Ref:- AW/43/18/OUT-261 Aldwick Road, PO21 3QU.
Planning Application.

22nd March 2018

re: Planning Application AW/43/18/OUT--261 Aldwick Road, PO21 3QU.

*proposed site plan*

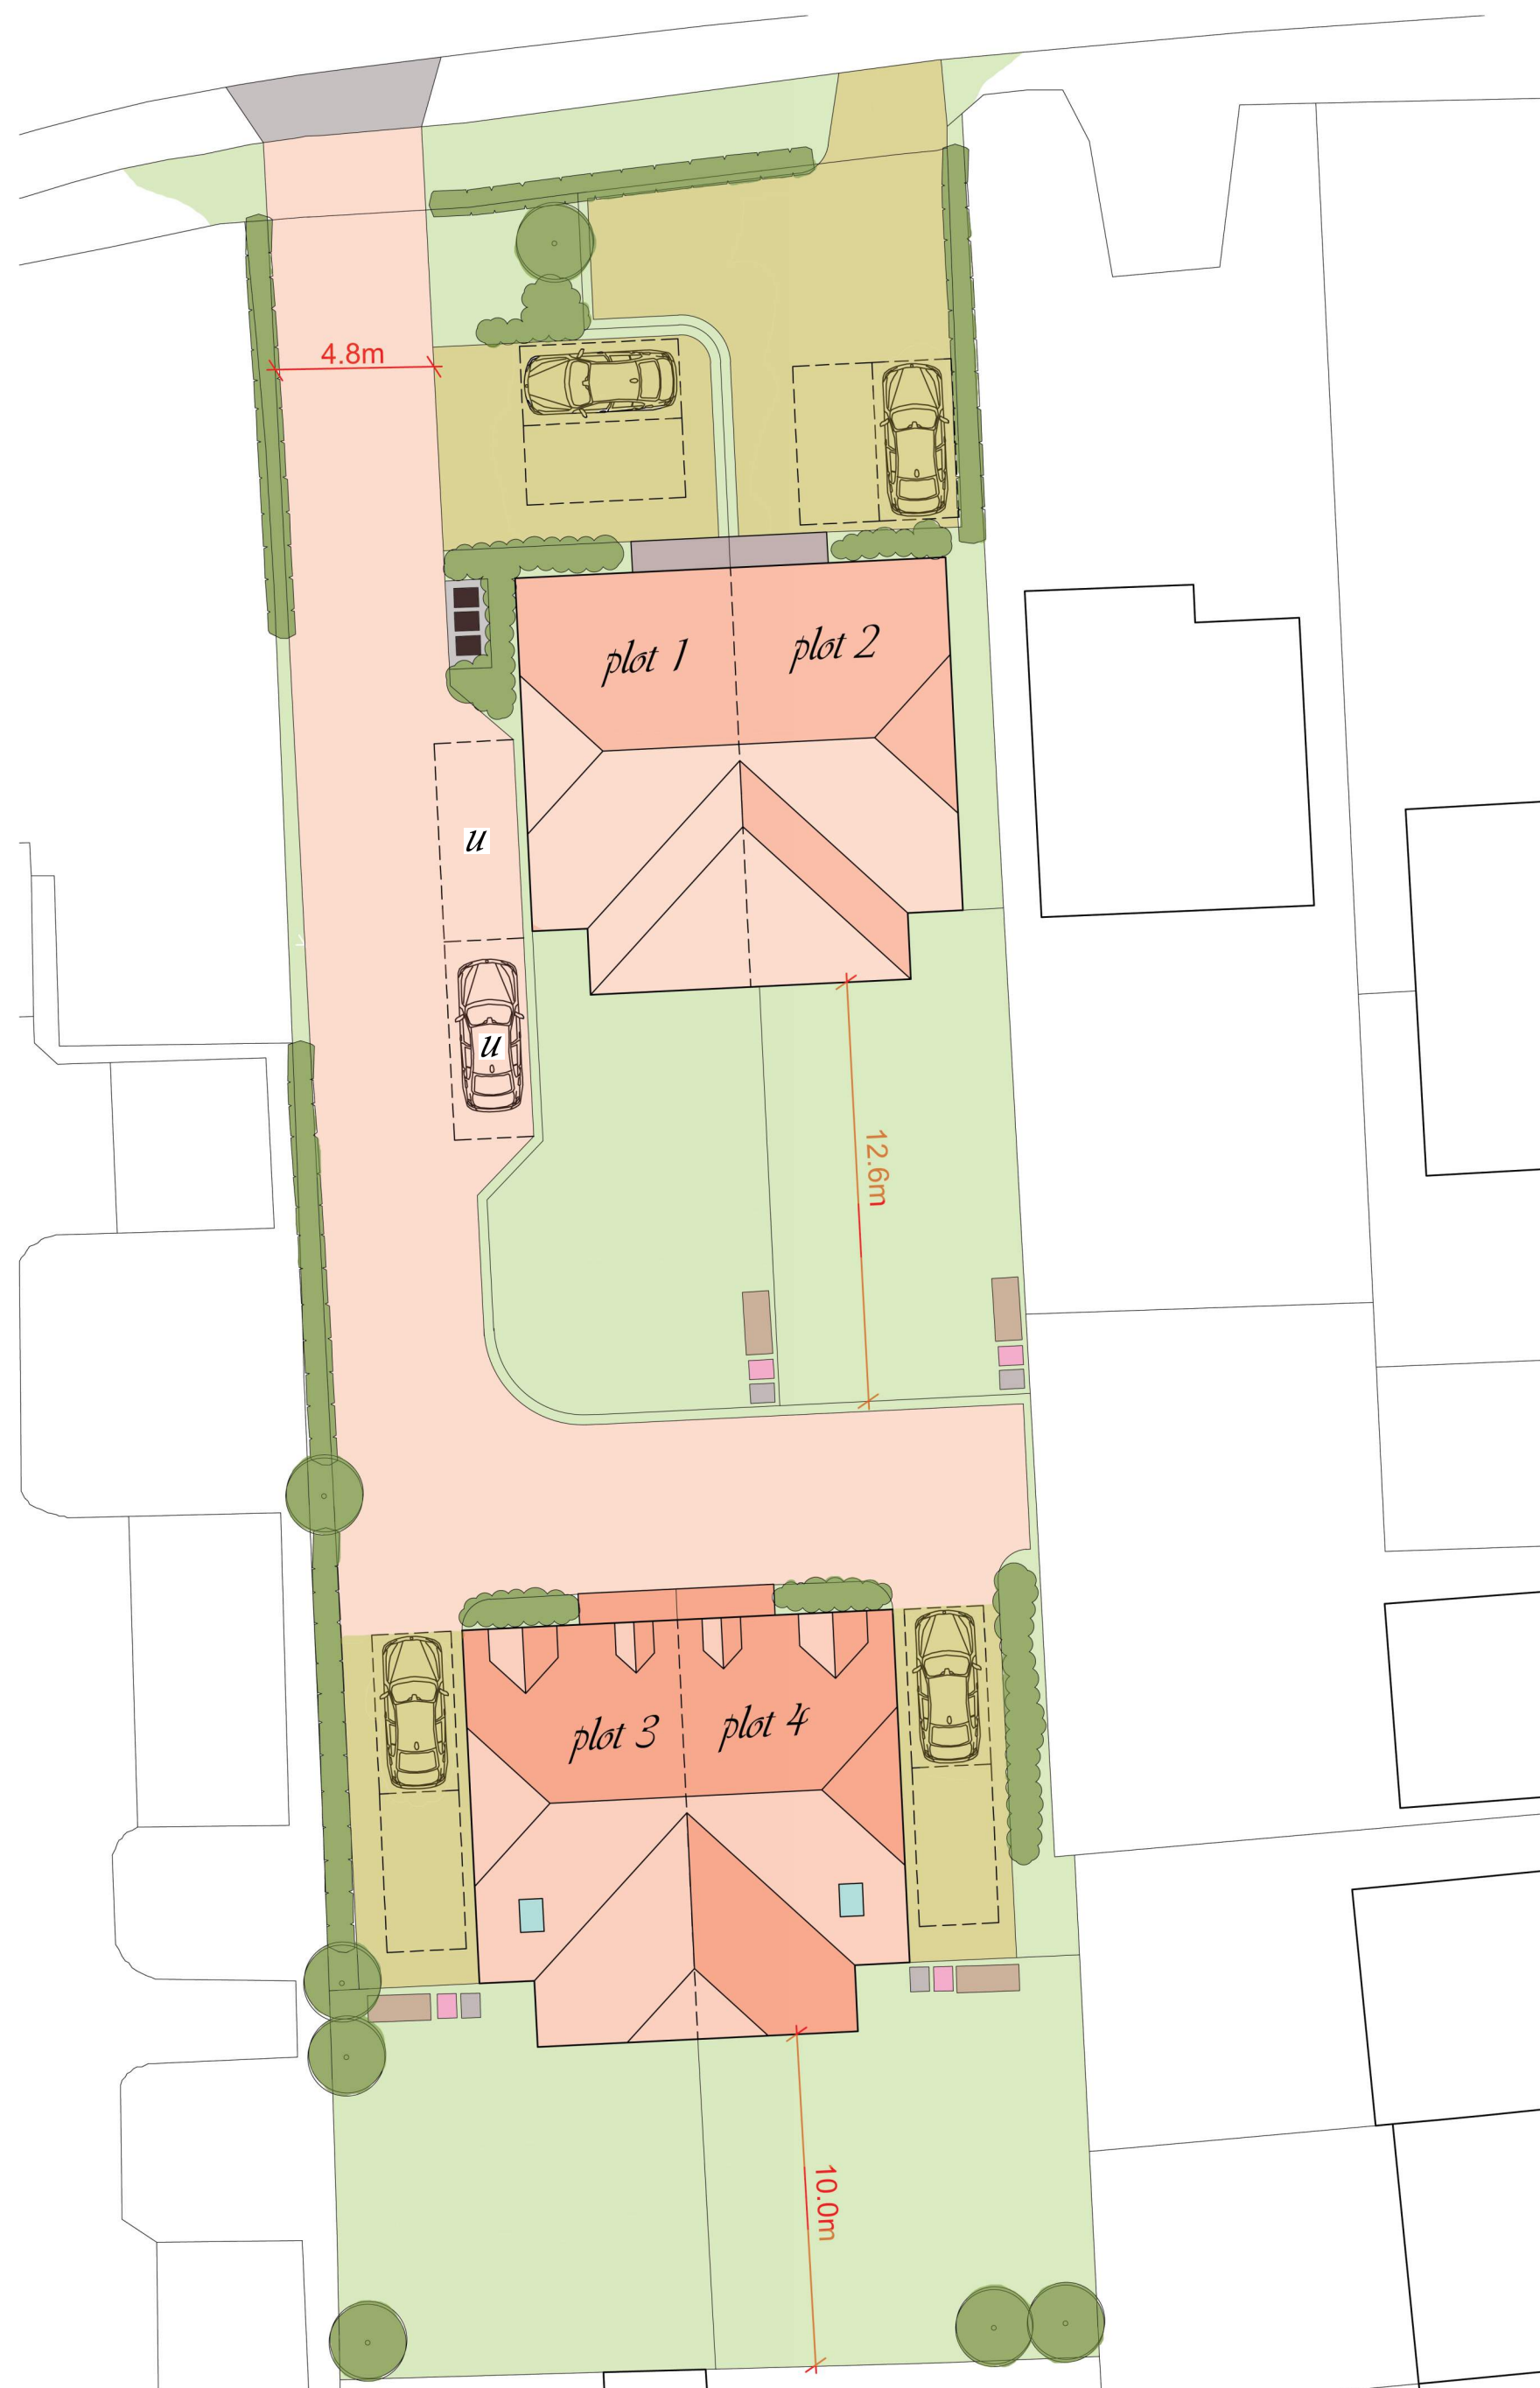
1. I am very concerned that two blocks of semi-detached four bedroom houses are proposed on this site. This seems to be excessive as the dwellings would house families thereby taking away the present peaceful existence of all immediate neighbours, and residents of Malmayne Court in particular, most of whom are elderly. It is likely that as the proposed road is so close to the fence of neighbouring Malmayne Court, air pollution from vehicle fumes is a potential threat.

2. The number of people living in the proposed development as well as the additional visitors, delivery and owner vehicles, would cause noise and disturbance detrimental to the health of elderly residents.
The use of the bin and bike store potentially presents an additional noise problem. Any disturbance to residents and immediate neighbours of Malmayne Court could be detrimental to their health and wellbeing.

3. It is to be hoped that no windows facing Malmayne Court would be allowed on any new property built on the site. Windows facing Malmayne Court would take away the privacy of the residents of Malmayne Court.
